Arun District Council
Arun Civic Centre
Maltravers Road
Littlehampton
West Sussex BN17 5LF
Planning General Enquiries
Tel: (01903) 737756 Fax: (01903) 730442
Dx: 57406 Littlehampton
Minicom: 01903 732765
e-mail: planning@arun.gov.uk
website: www.arun.gov.uk/planning

Town & Country Planning Act 1990 (as amended)
Town and Country Planning (Development Management Procedure) (England) Order 2015
Application for approval of details reserved by conditions imposed under planning permission
FG/37/17/PL relating to condition No. 3 (Schedule of materials), 4 (Surface water drainage), 6
(Construction Management Plan) & 8 (Landscaping scheme)
Onslow Caravan Park Onslow Drive, Ferring,

Arun District Council have decided to **REFUSE details reserved by condition for the following reasons:**

Simon Jones-Parry BSc CEng MICE Chartered Civil Engineer Swans Farm Winchfield Hook RG27 8DB Tel 01256 704940			
Island Meadow Parks		DRAINAGE PLAN - PLANNING CONDITION 4	
NEW MACHINERY STORE AT ONSLow DRIVE, FERRING		Scale 1:250	Date 03.11.17 Drawing No 100

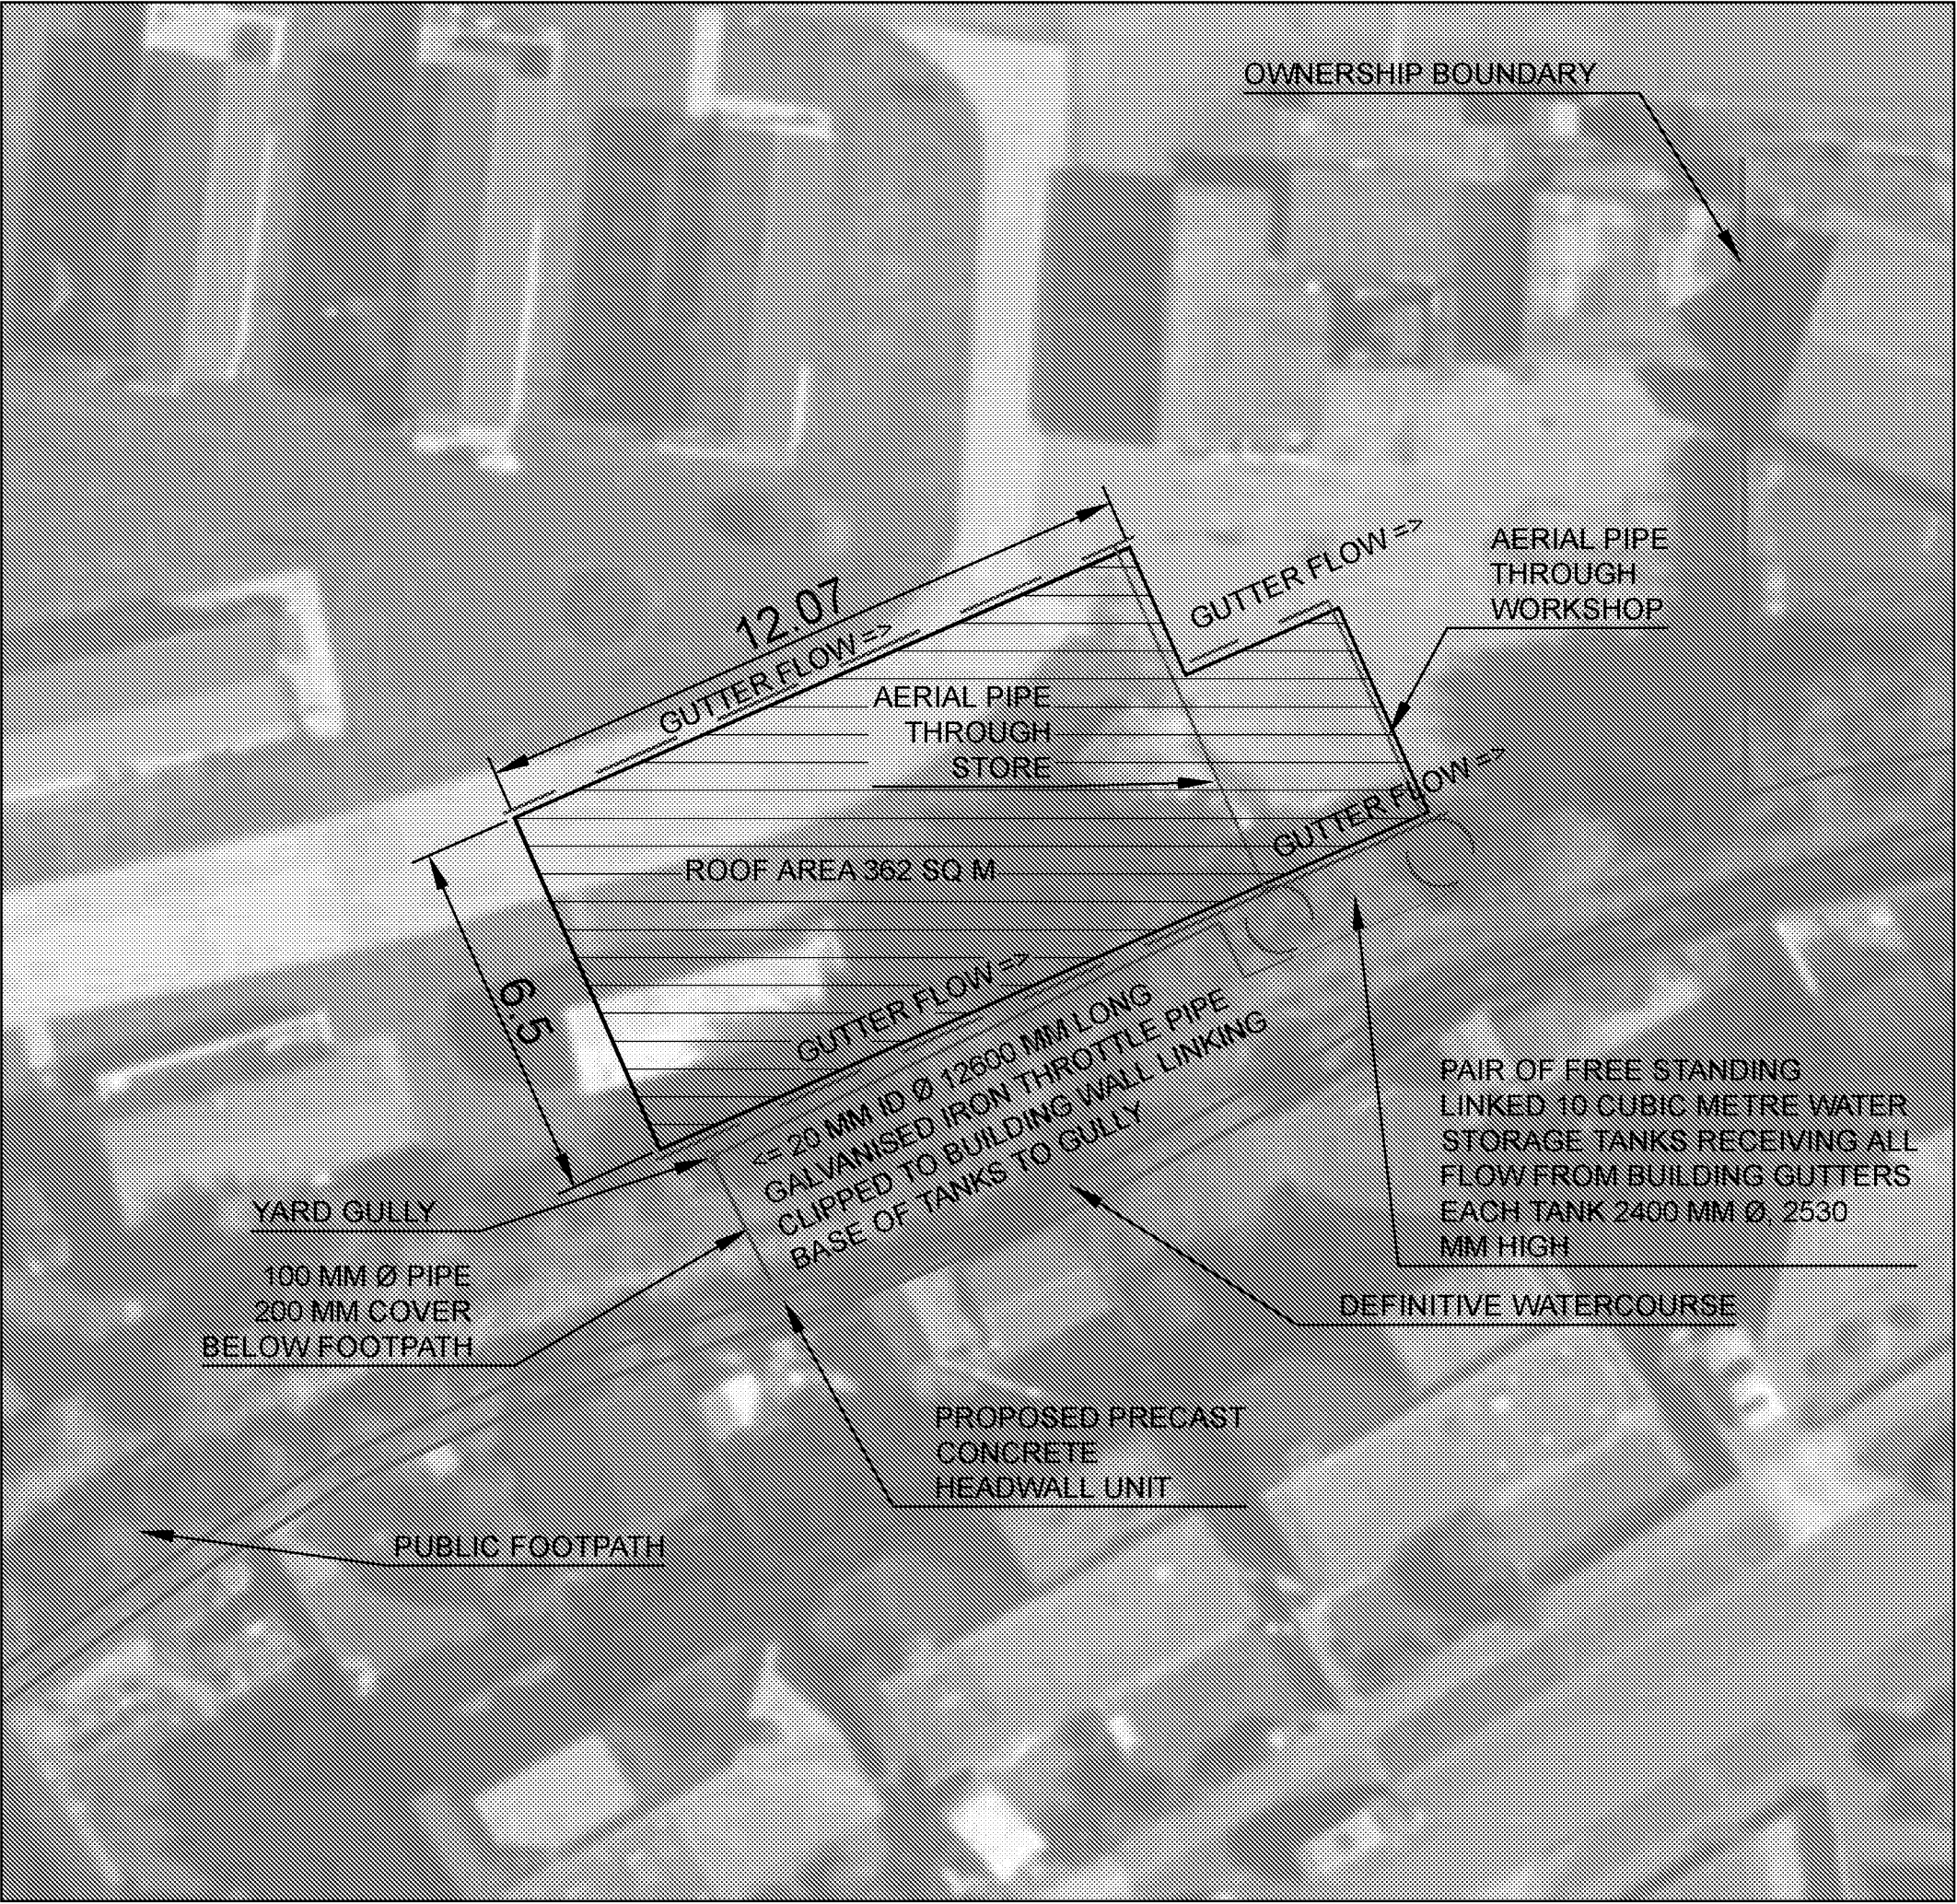
1. The applicant has not undertaken winter groundwater monitoring or percolation testing. However, the percolation results obtained in September do not favour infiltration. Therefore, a discharge to the adjacent watercourse is required as proposed.
2. The applicant will need to provide a fully detailed drainage plan including cover/invert levels/ditch bed levels/all pipe diameters, gradients, etc.
3. Full construction details will be required including the gully/headwall/any manholes/silt traps, docdeci

4. More detailed information is required on the above ground storage tanks in terms of inlet and outlet levels, etc.

The proposed restricted discharge is noted, however, the pipe diameter is a concern ie.20mm. The system needs to be robust in terms of prevention of pipe blockage and the tanks need to accommodate the 1 in 100 year event + 30% allowance for climate change. Storm durations from and including 15 mins need to be accommodated. How the flows will be restricted required more discussion.

5. Flows from any new hardstandings need to be accommodated in the system. Please confirm/verify/detail arrangements.

6. Silt must be collected/controlled via sumps.

7. The headwall must be of such construction as not to encroach into the profile/flow area of the ditch and also mindful of the public right of way footpath running alongside, as not to present a safety issue.
